Holbeach Road, Spalding

Highways Technical Note

Response to Highways Comments from Lincolnshire County Council

Planning Application Reference: 25/0704/FUL

Appendix E
Traffic Flow Diagrams

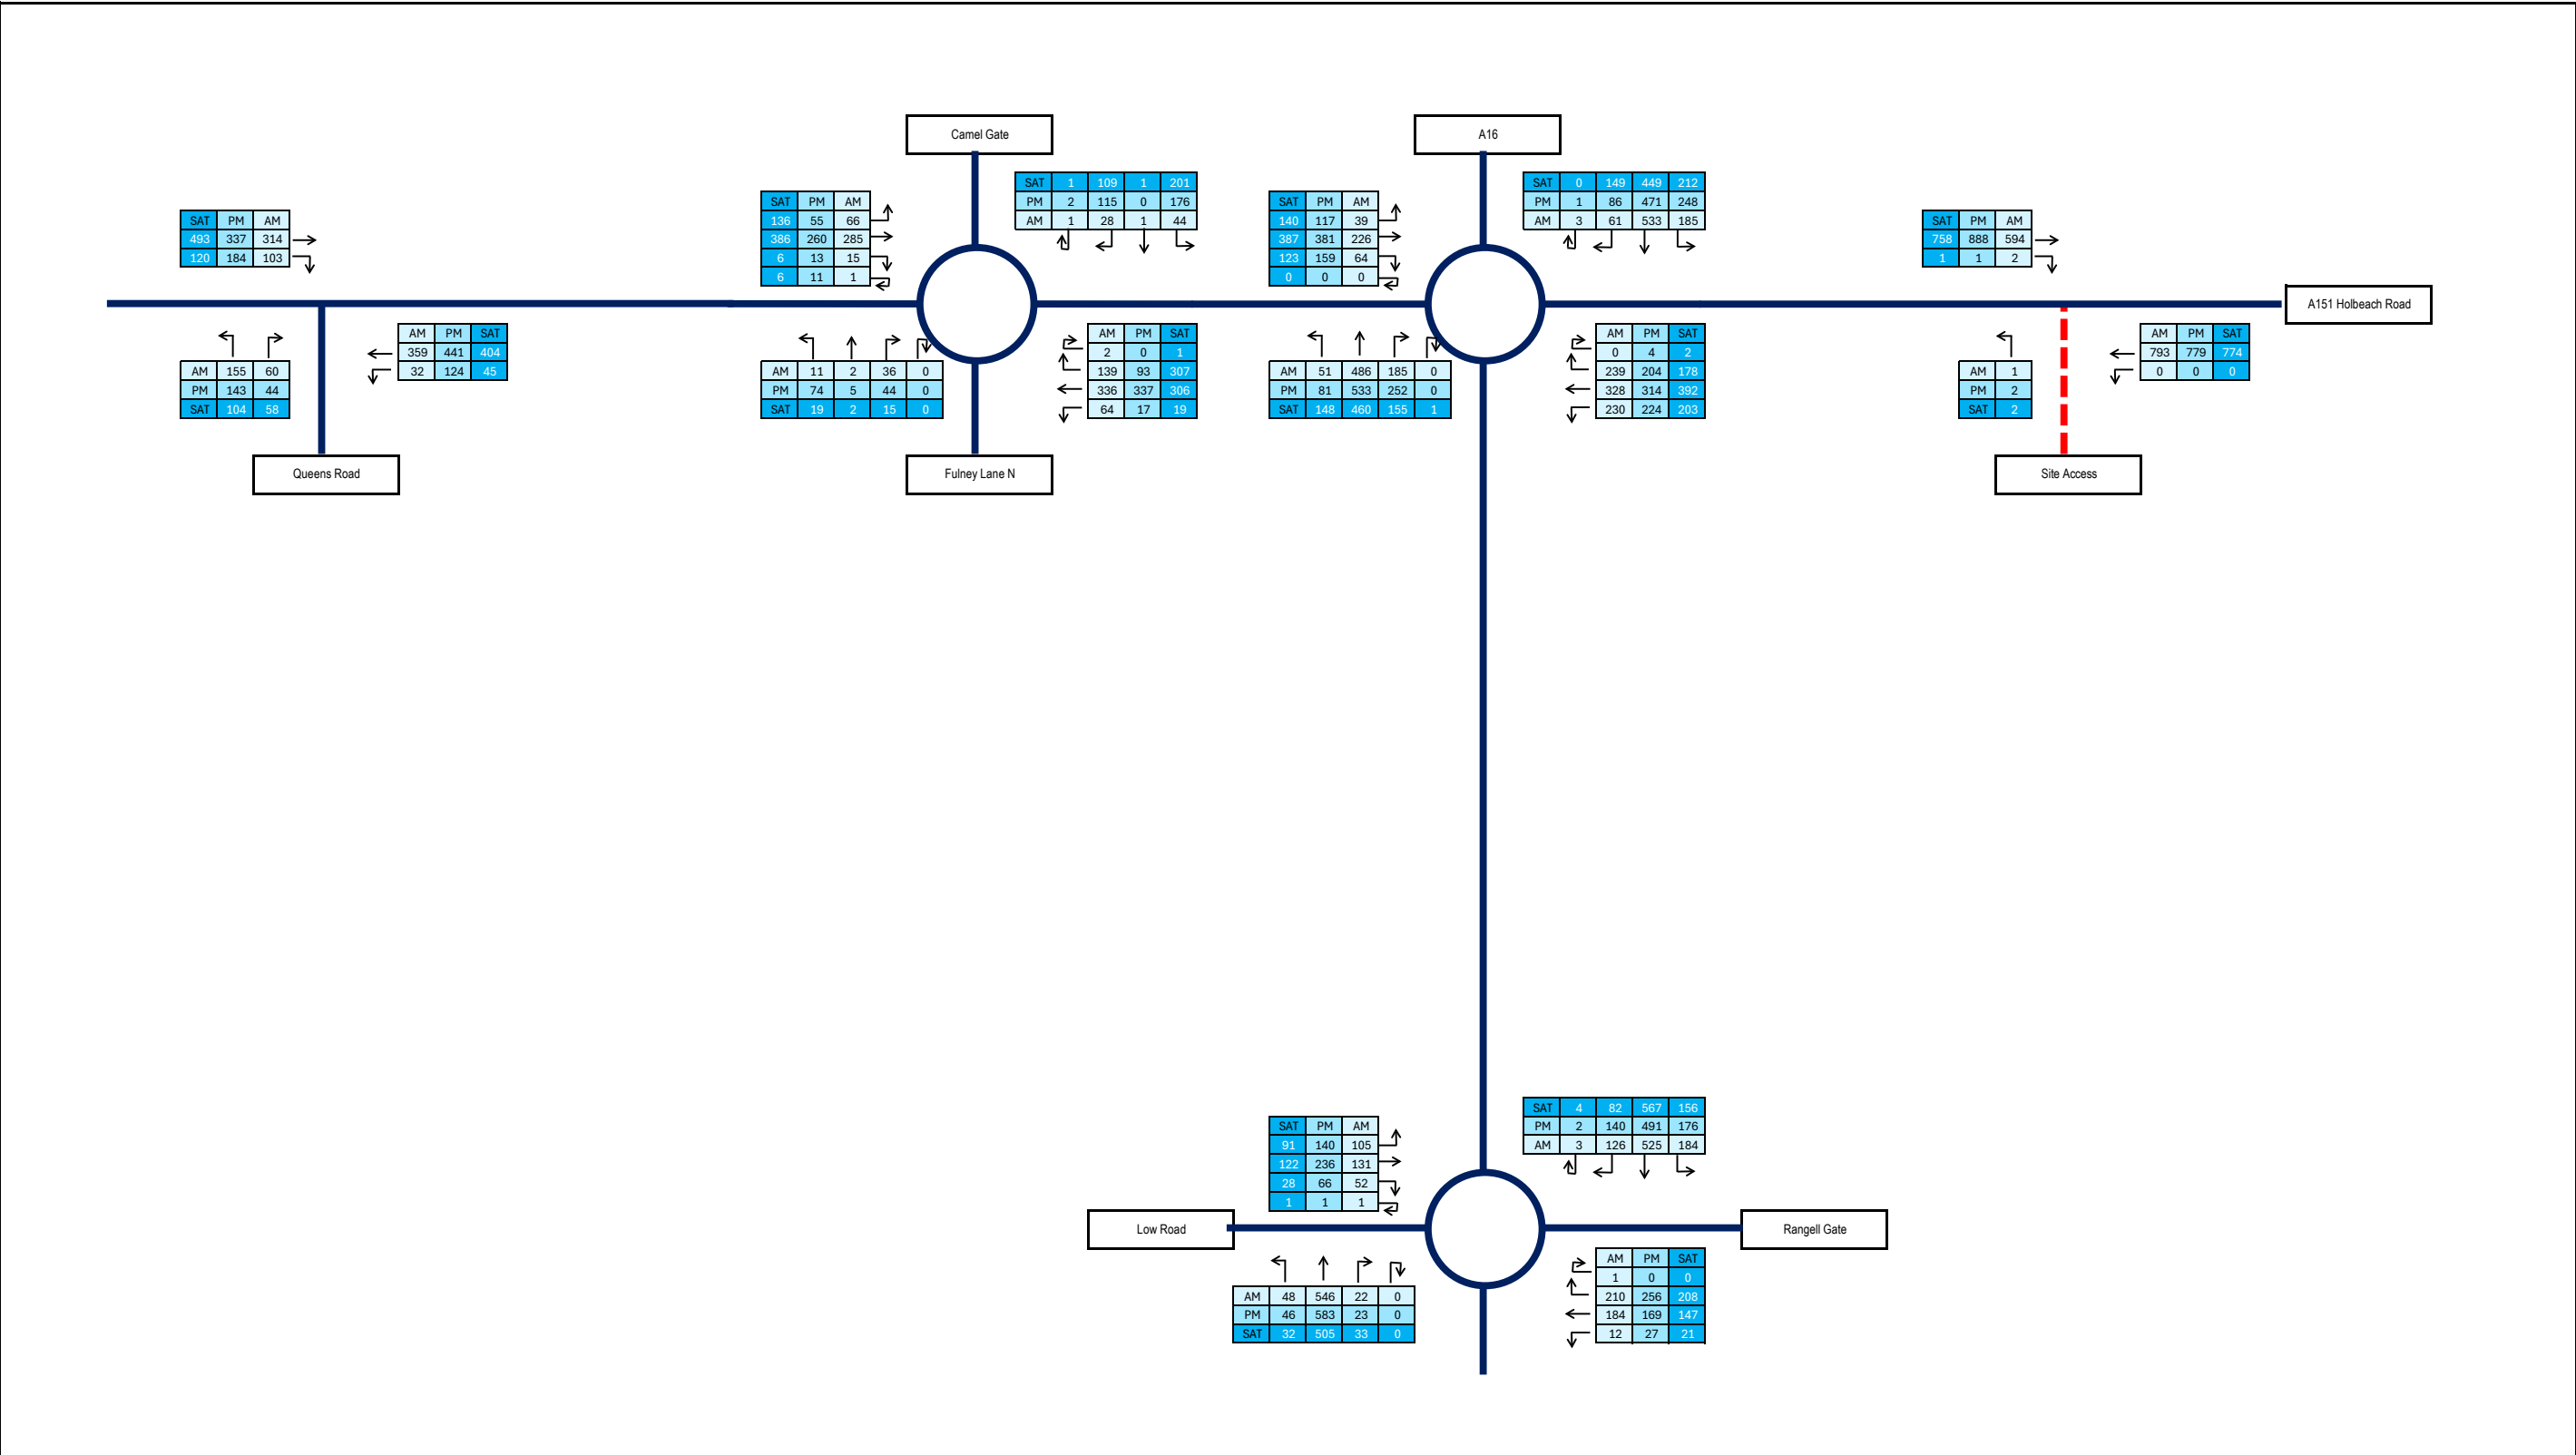
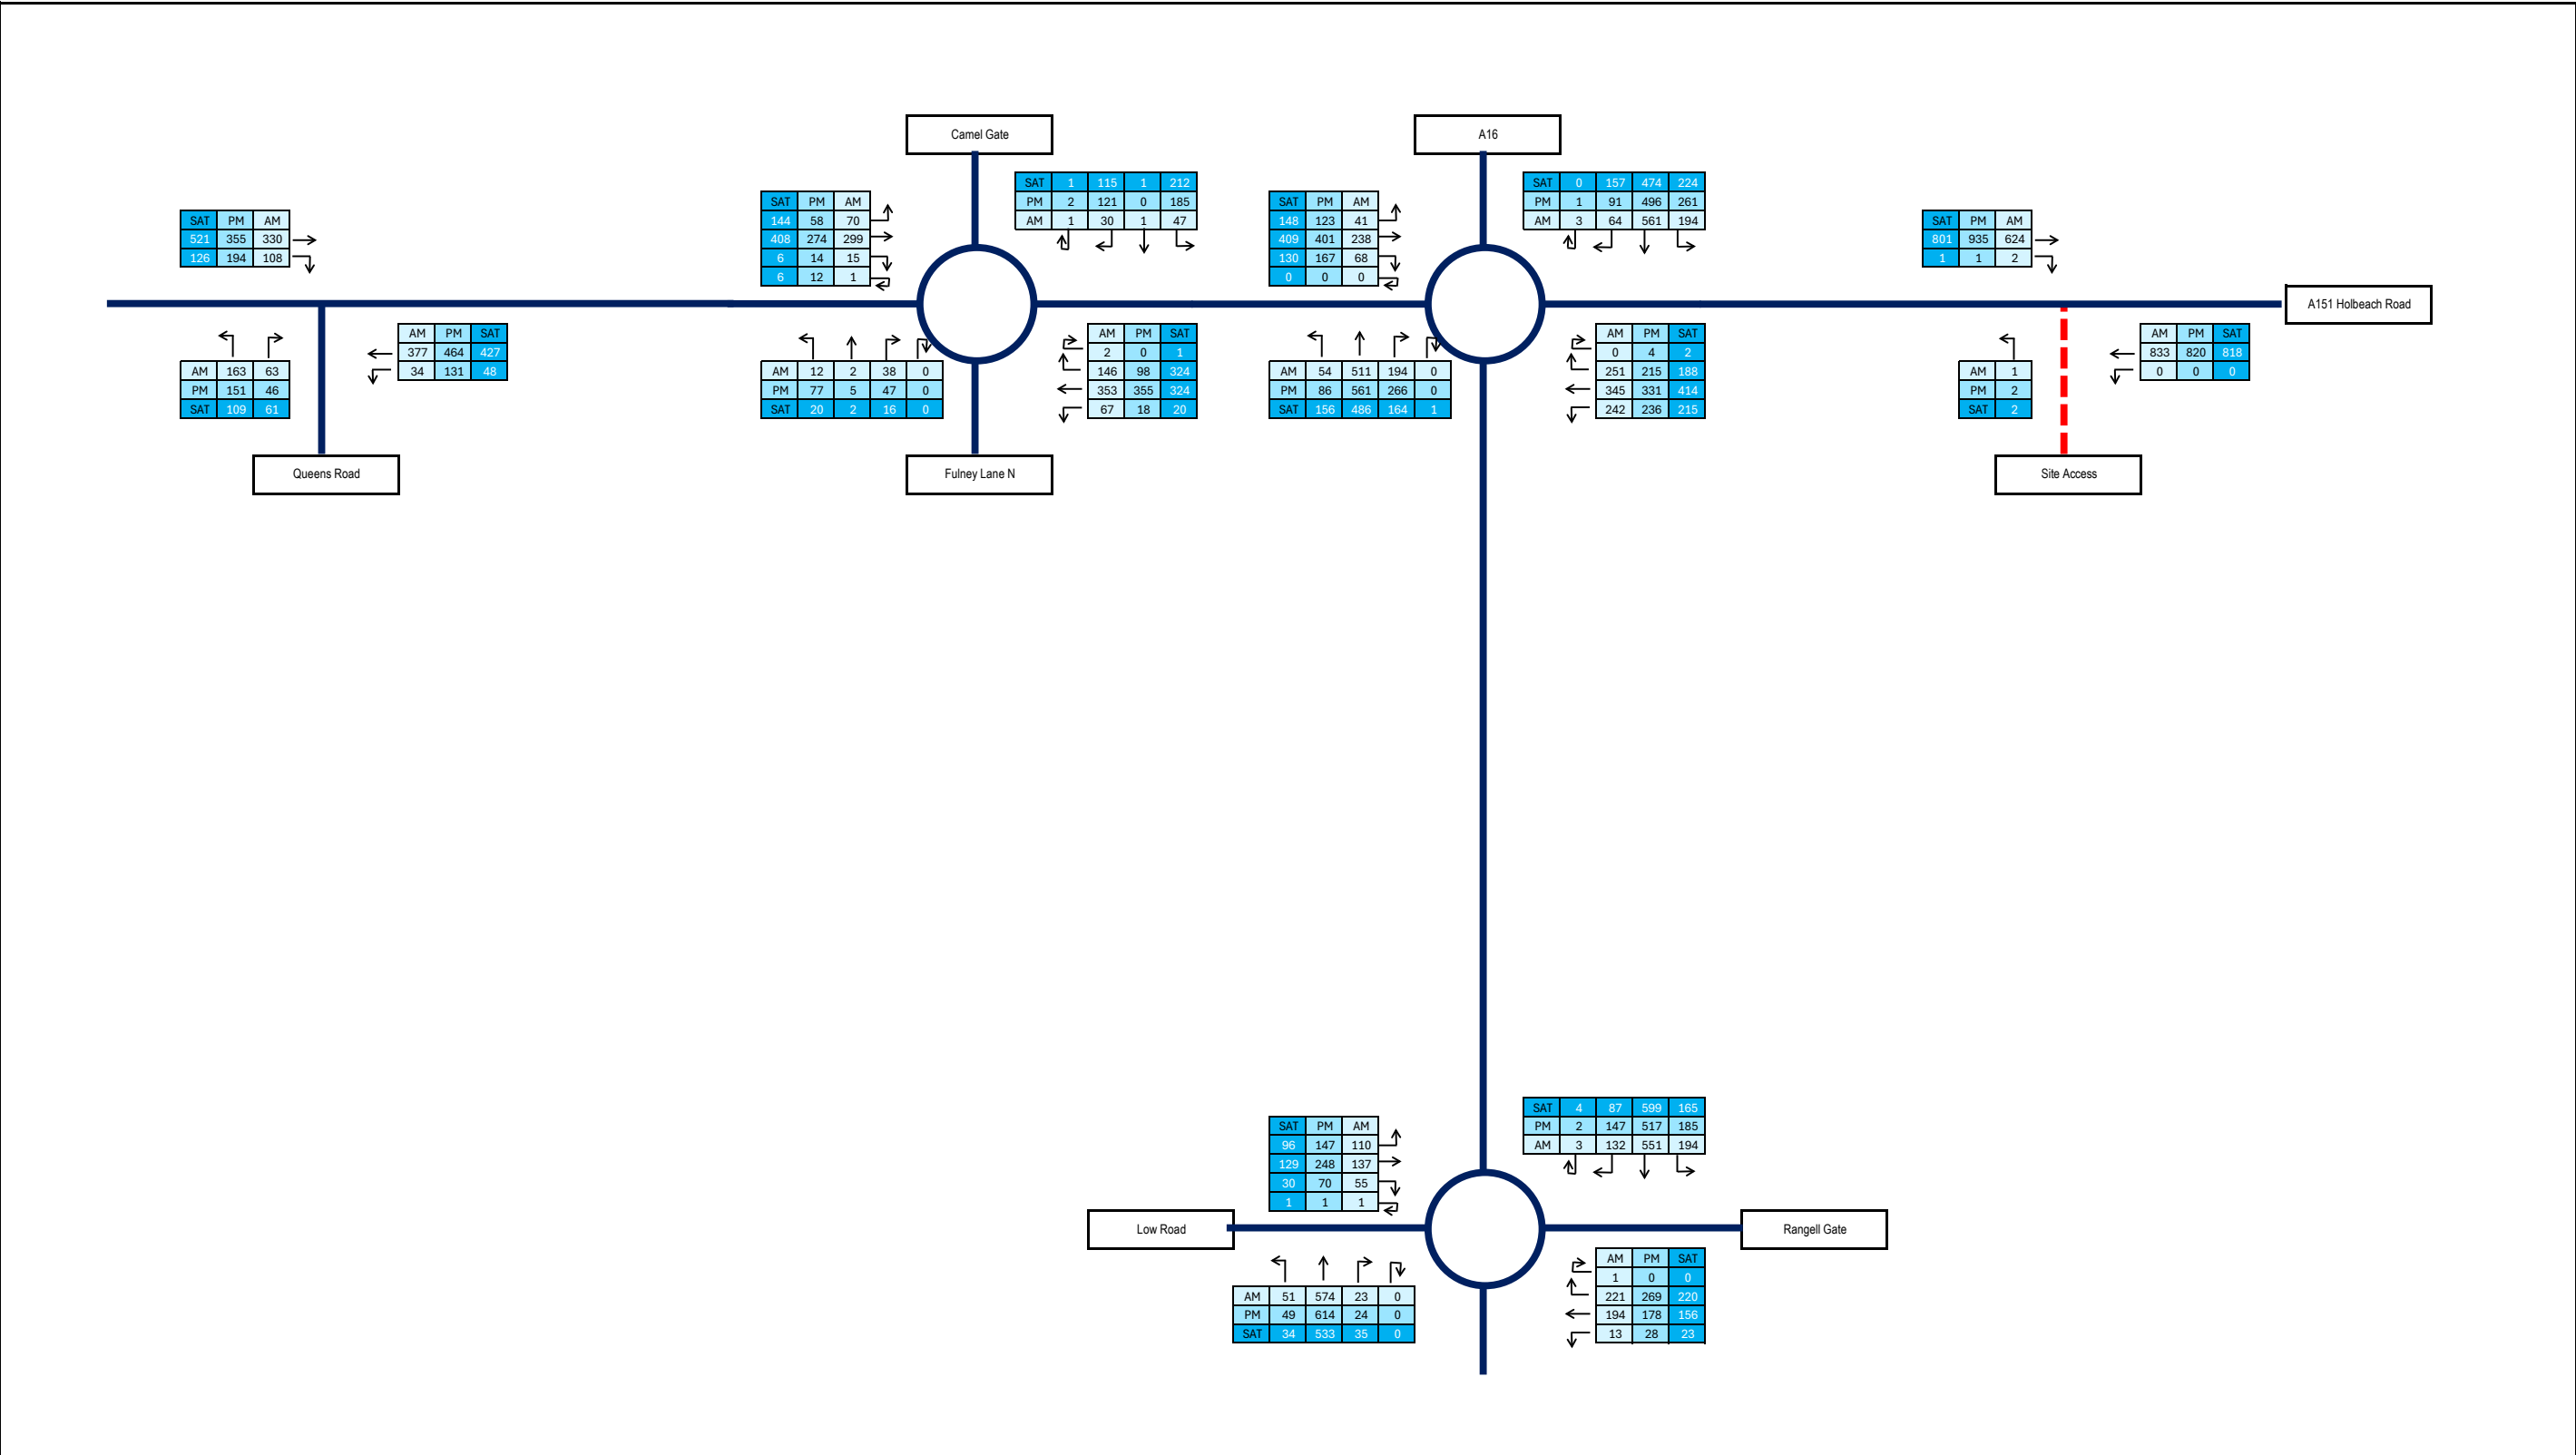
We have significant concerns about the access arrangements. Pre app discussions were based on different access arrangements.

The A16 roundabout improvement scheme designed Ghost Island Right Turn Lane for residential use and is as existing. It is not built to DMRB standard. Stacking is not available for service vehicles expected to visit the site. There is the potential for vehicles to back up over the roundabout - capacity concerns.

There is significant highway signage that will need moving to accommodate the access – this has not been addressed and relocation details provided. The street lighting may also need moving.

The tracking is unworkable at peak hours as HGV's will need to take up both lanes exiting the site. The swing that is needed can't be achieved on the access road without moving the stone pillars – we need security that they can be moved.

While it is noted that the access junction doesn't comply with DMRB in terms of the length of the ghost island right-turn facility, it is still considered acceptable in this location. This is due to the proximity of the site access junction to Springfield Roundabout. A 50m ghost island right-turn facility is typically required on a 40mph road which is required for deceleration. Drivers entering the right-turn ghost island facility in this location will be exiting Springfield Roundabout, therefore, a 50m length is not required. A 38m ghost island facility in this location is considered appropriate given that it's similar to the 35m requirement for a 30mph speed limit. Vehicles exiting Springfield Roundabout onto the A151 Holbeach Road are likely to be travelling at 30mph before accelerating towards the 40mph speed limit as they continue north-eastbound on the A151 Holbeach Road.

In terms of stacking spaces for a HGV waiting to turn right into the site, 38m is more than sufficient given that a max legal articulated HGV is 16.5m long.

Items such as relocating signage and street lighting can be dealt with at the detailed design stage.

The site will have a delivery strategy in place that ensures that HGVs arrive outside of the peak periods. The stone pillars will be removed / relocated as they conflict with the eastern carriageway edge of the proposed site access road.
